### MEMORANDUM

TO: Jeff Watson, Community Development Services

SUBJECT: Longbine SP-10-00002

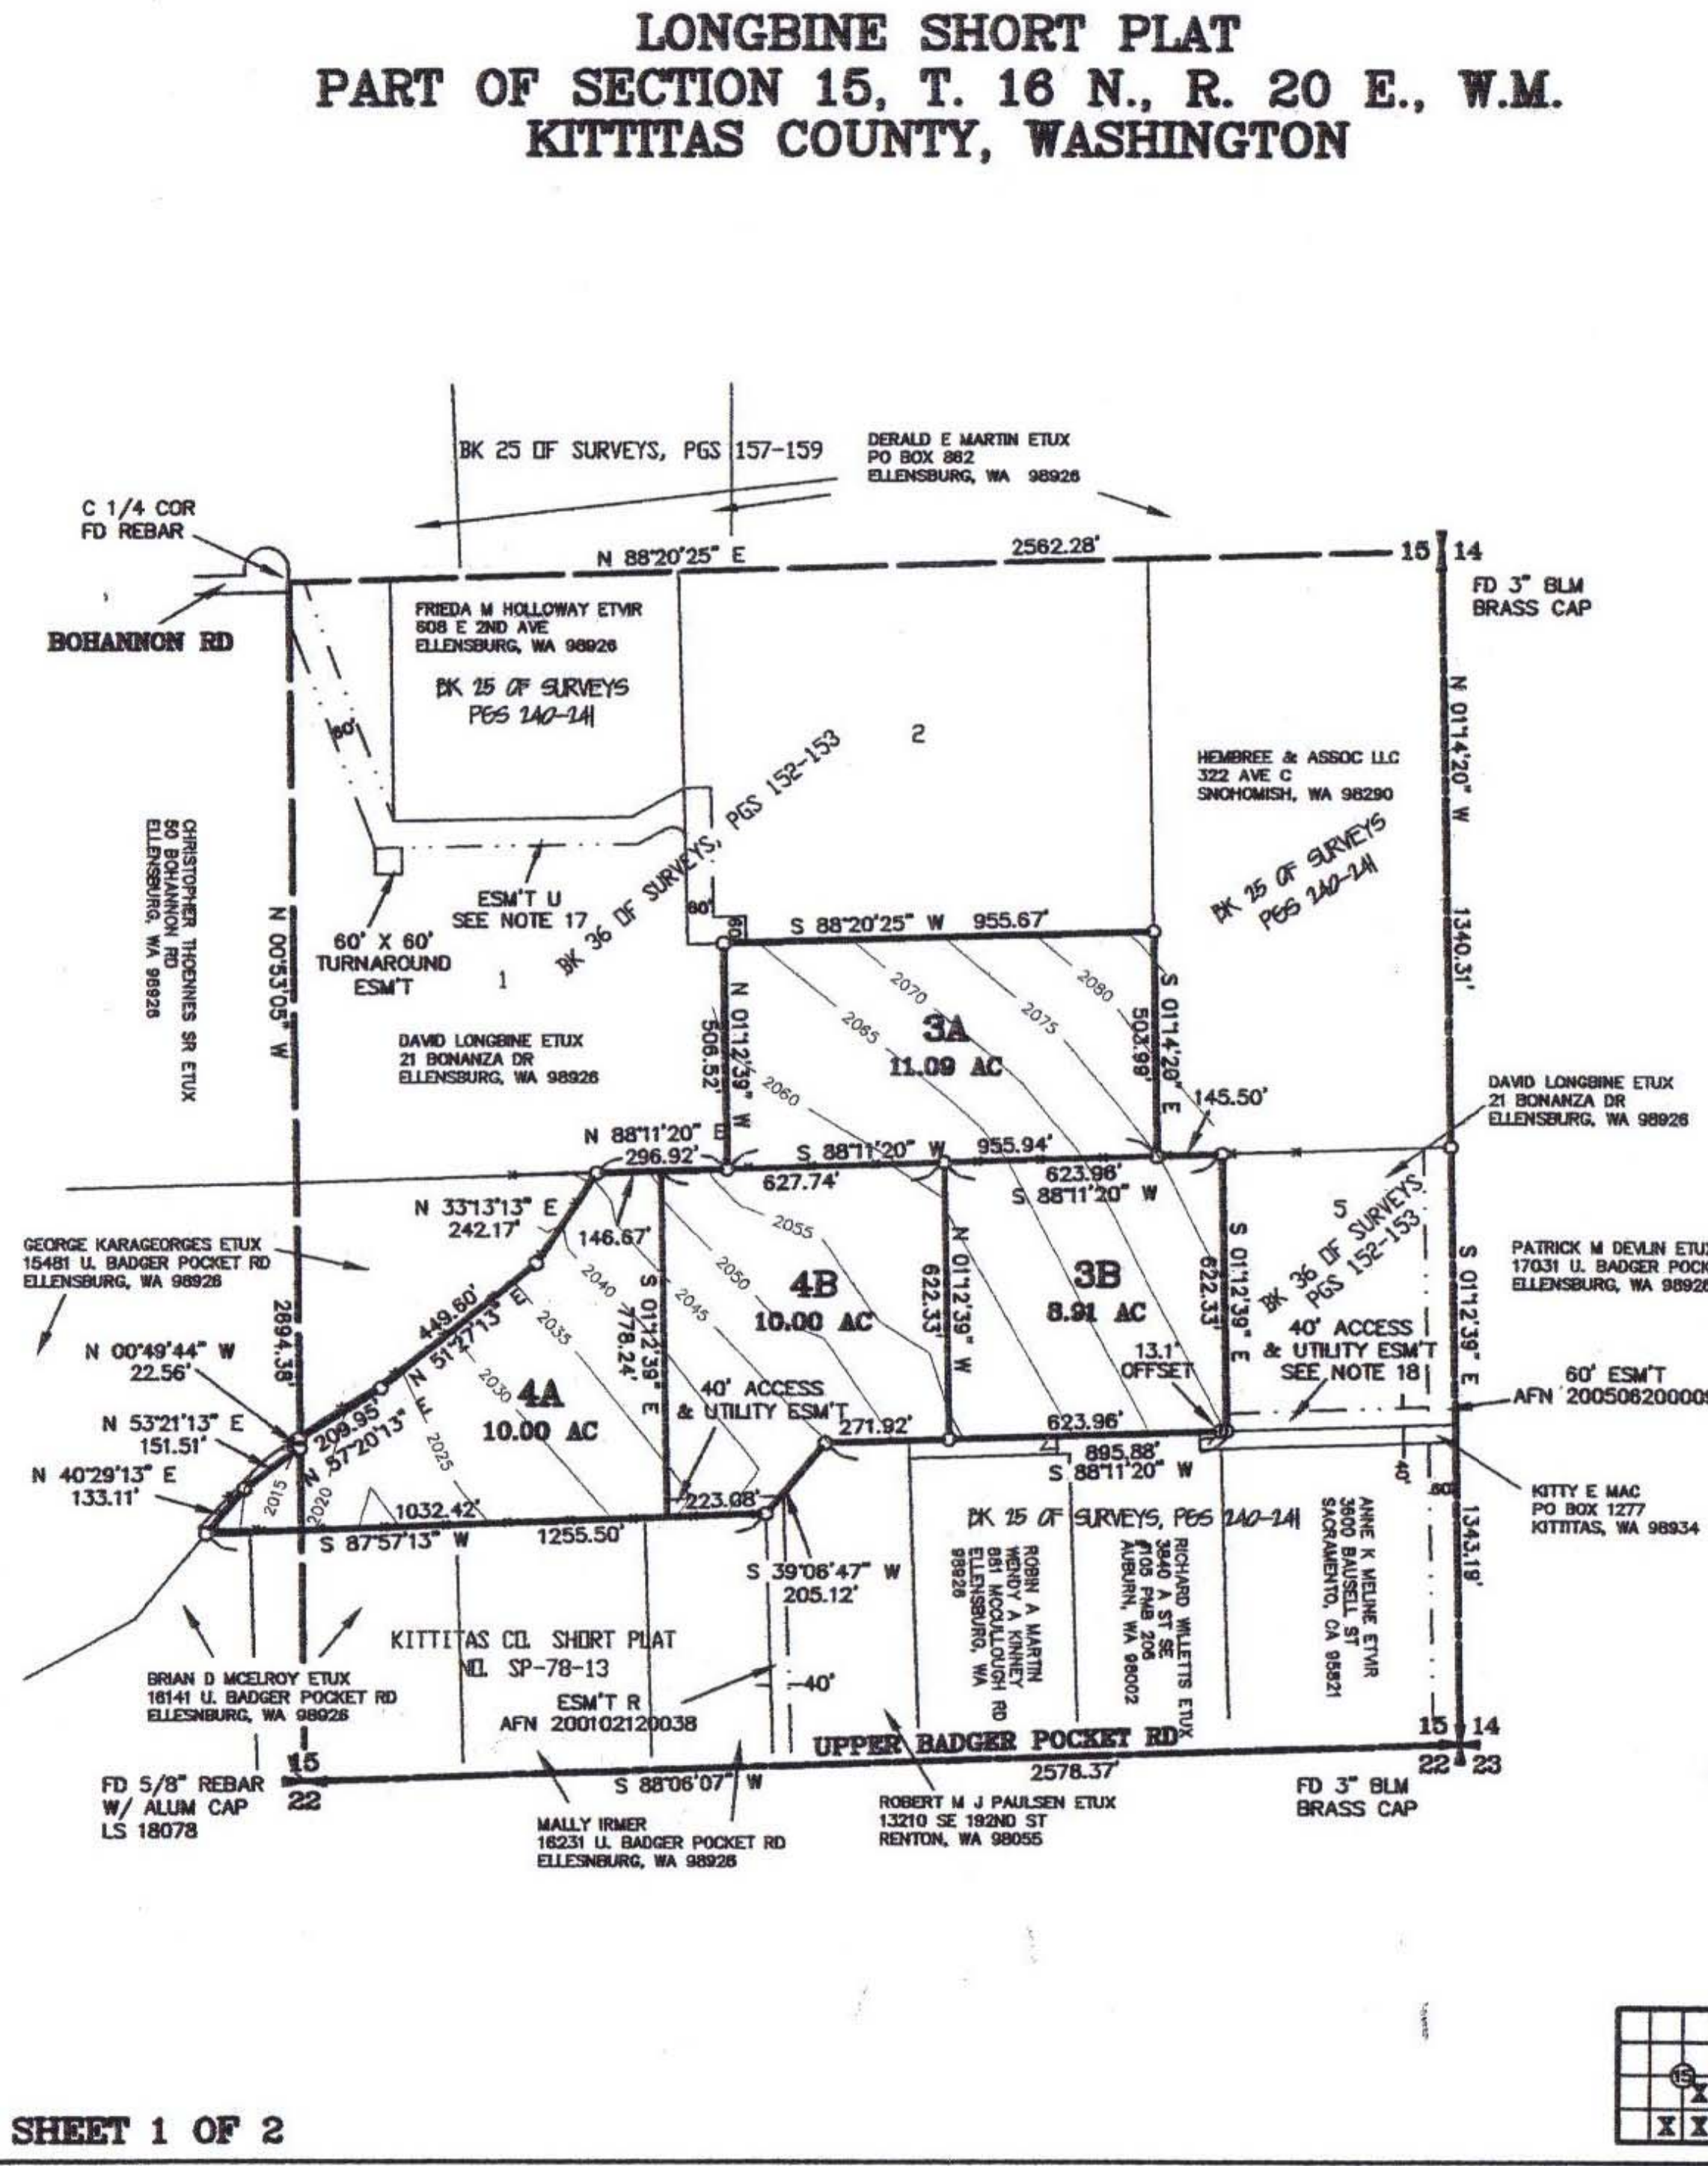
3. Plat Notes: Plat notes 17 and 18 on the revised plat drawings may be removed from the plat.
4. Private Road Improvements: The access road within easement "U" shall be constructed to meet or exceed the requirements of a Low-Density Private Road from the end of Bohannon Road to the hammerhead turnaround located on Lot 1. Beyond the hammerhead turnaround, the road may be constructed as a joint-use driveway to serve lots 2 and 3A. If any additional lots are served off easement "U", easement "U" will require further improvements. The hammerhead turnaround easement shall be located at least 60' east of the proposed location to allow for a T-shaped turnaround rather than the proposed Y-shape.

The access road within the easement serving lots 3B and 5 shall be constructed to meet or exceed the requirements of a Low-Density Private Road from Upper Badger Pocket Road to an emergency turnaround. A hammerhead turnaround may be placed at the intersection of the 60' easement and the 40' easement at the southeast corner of lot 5. No additional easement is necessary.
